# CITY OF ALBUQUERQUE

December 23, 2014

**Re: Kirkpatrick Warehouse  
Kirkpatrick Warehouse Drainage Report with Engineer's Stamp dated 11-25-14  
Kirkpatrick Grading and Drainage Plan with Engineer's Stamp Dated 12-22-14  
(C17D122)**

ENGINEER'S SEAL 	TRACT B-1-A-5 CLIFFORD INDUSTRIAL PARK	DRAWN BY JDG
	GRADING AND DRAINAGE PLAN	DATE 11-26-2014
		SHEET # 1 OF 1
12/22/14 DAVID SOULE P.E. #14522	1606 CENTRAL AVENUE SE SUITE 201 ALBUQUERQUE, NM 87106 (505) 872-0999	JOB #

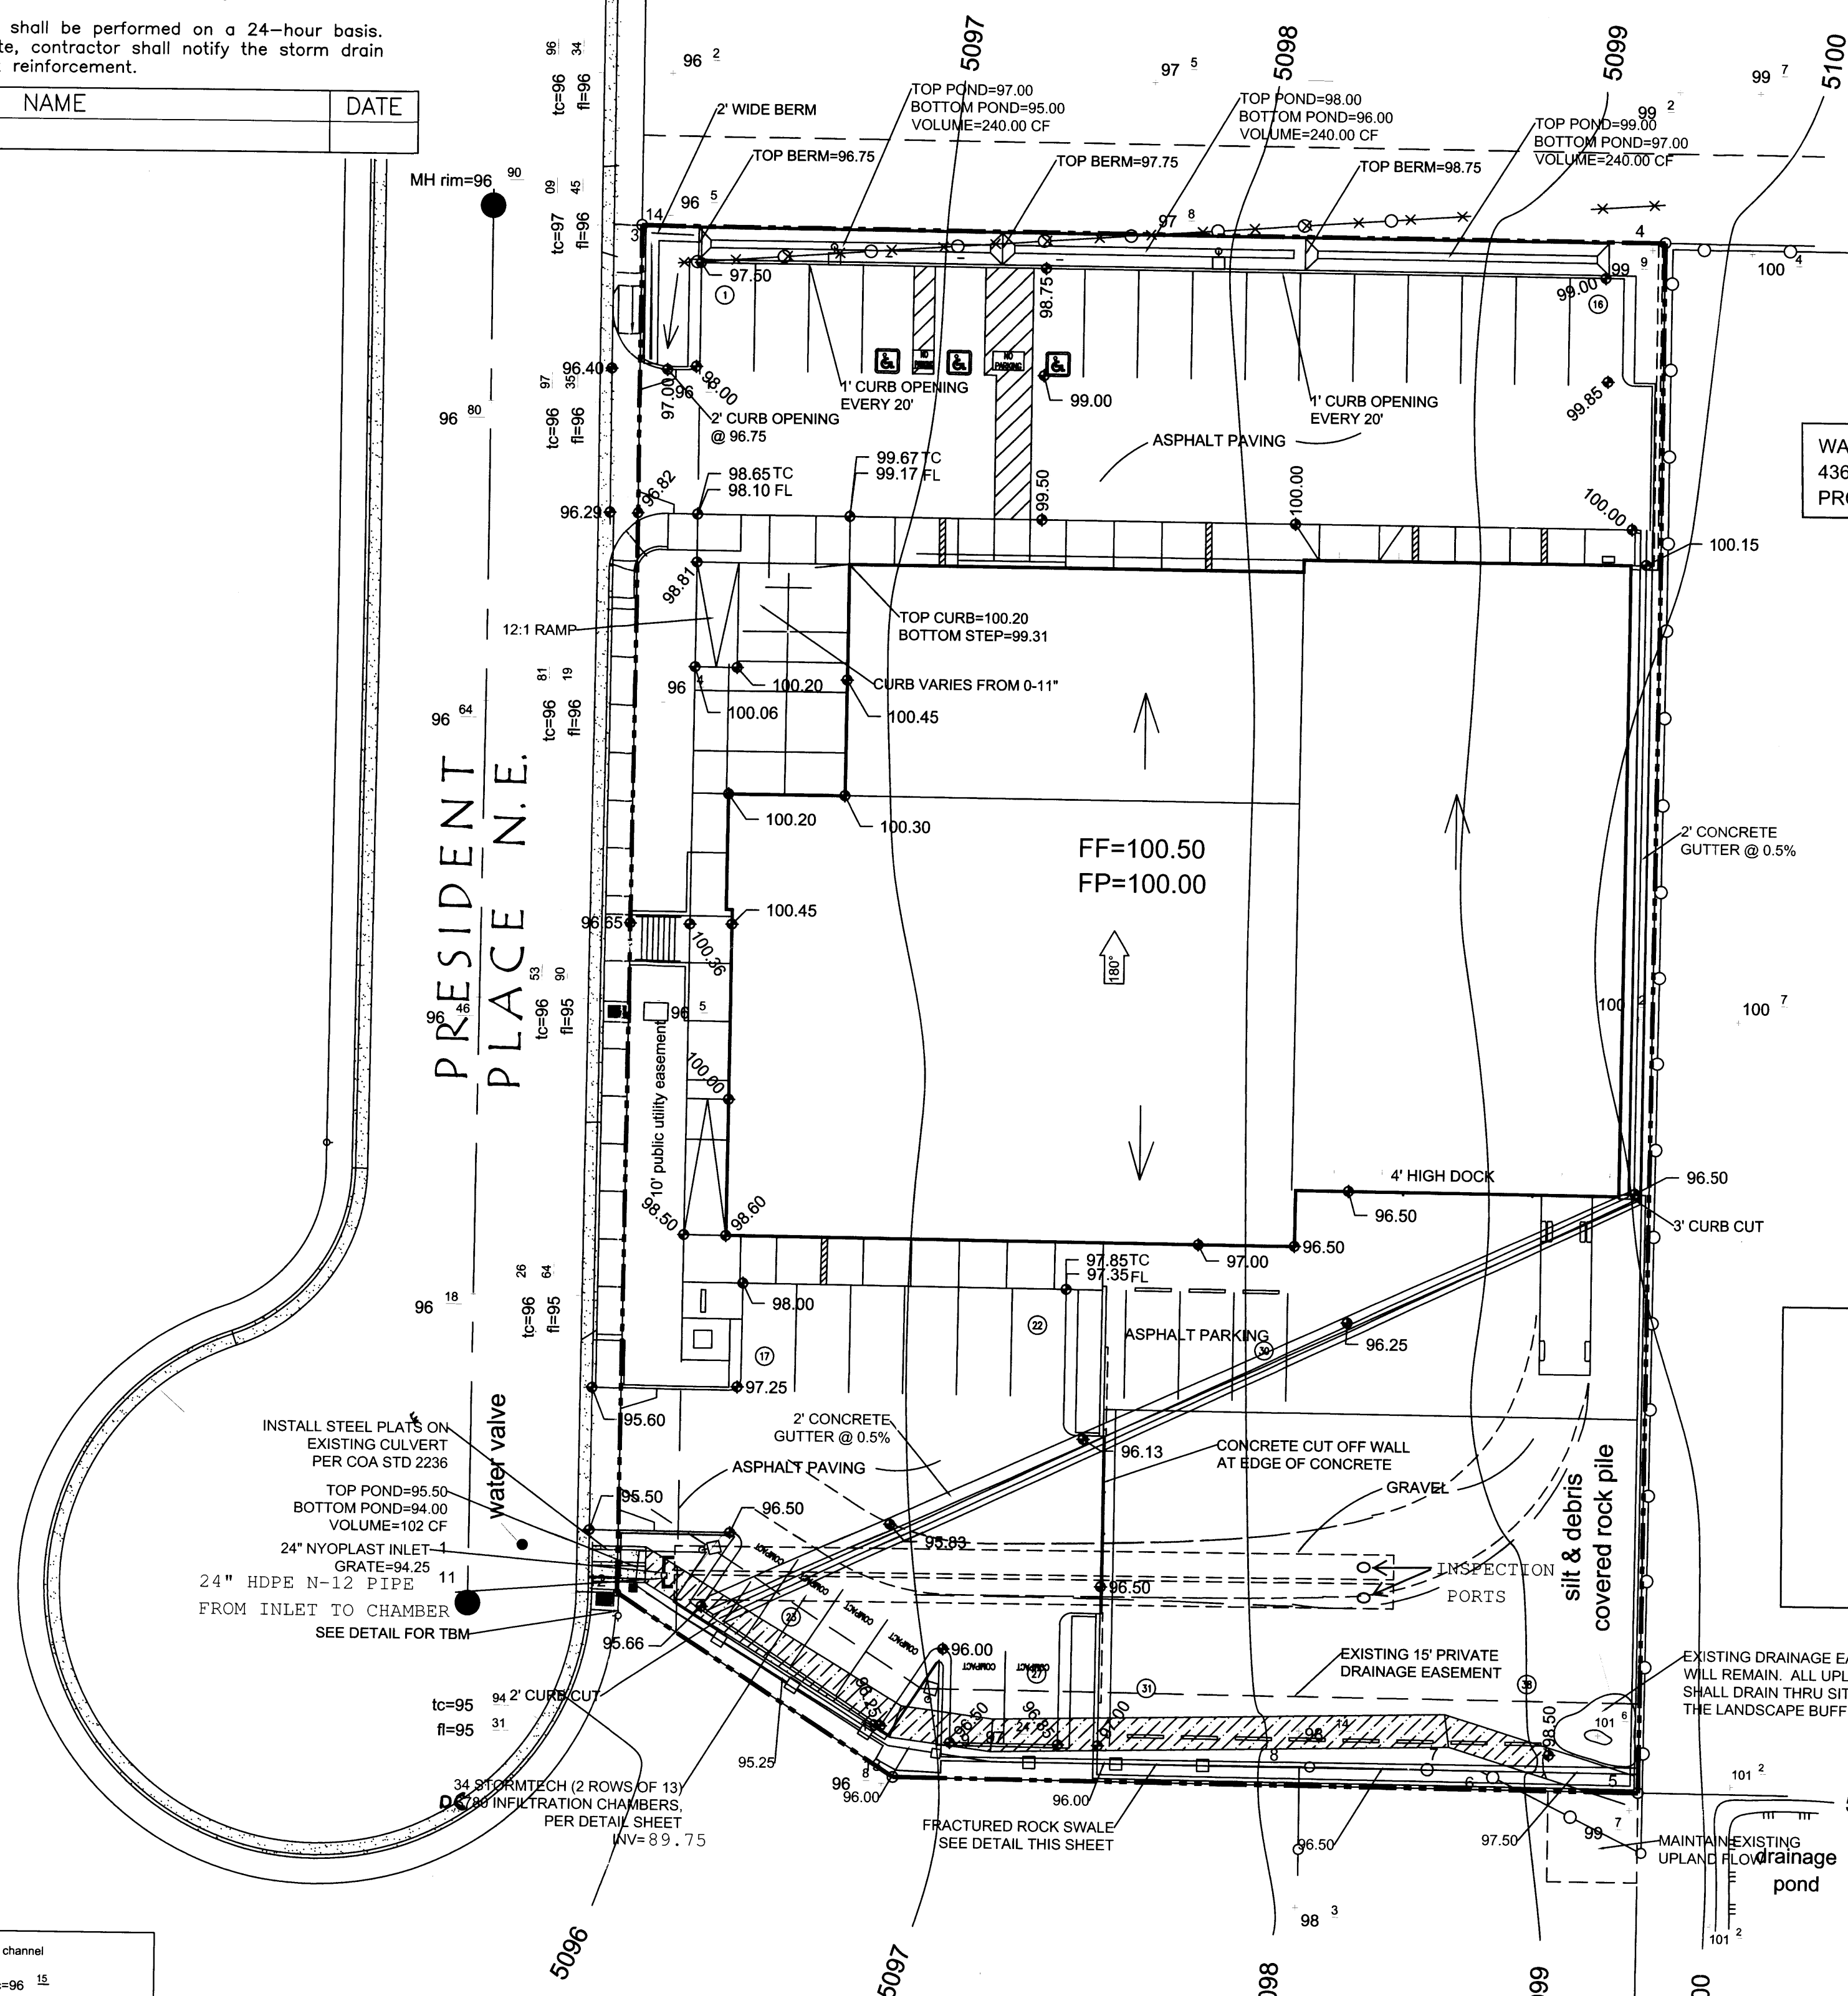
1. Include calculations for the design of the Stormtech system.
2. Provide a detail sheet for the Stormtech system that includes plan and profile views.
3. The inlet grate is at 94.25 but the invert is at 59.75. What should the invert really be at?
4. How will the manifold system be set up? How far apart are the rows? How will flows go into the isolator row? How will the isolator row be maintained and cleared of debris?
5. You have specified S780. Do you mean DC-780? What stub are you specifying?
6. What are the depths and type of stone for the whole system?
7. What kind of geotextile is being used? Where is the fabric located?
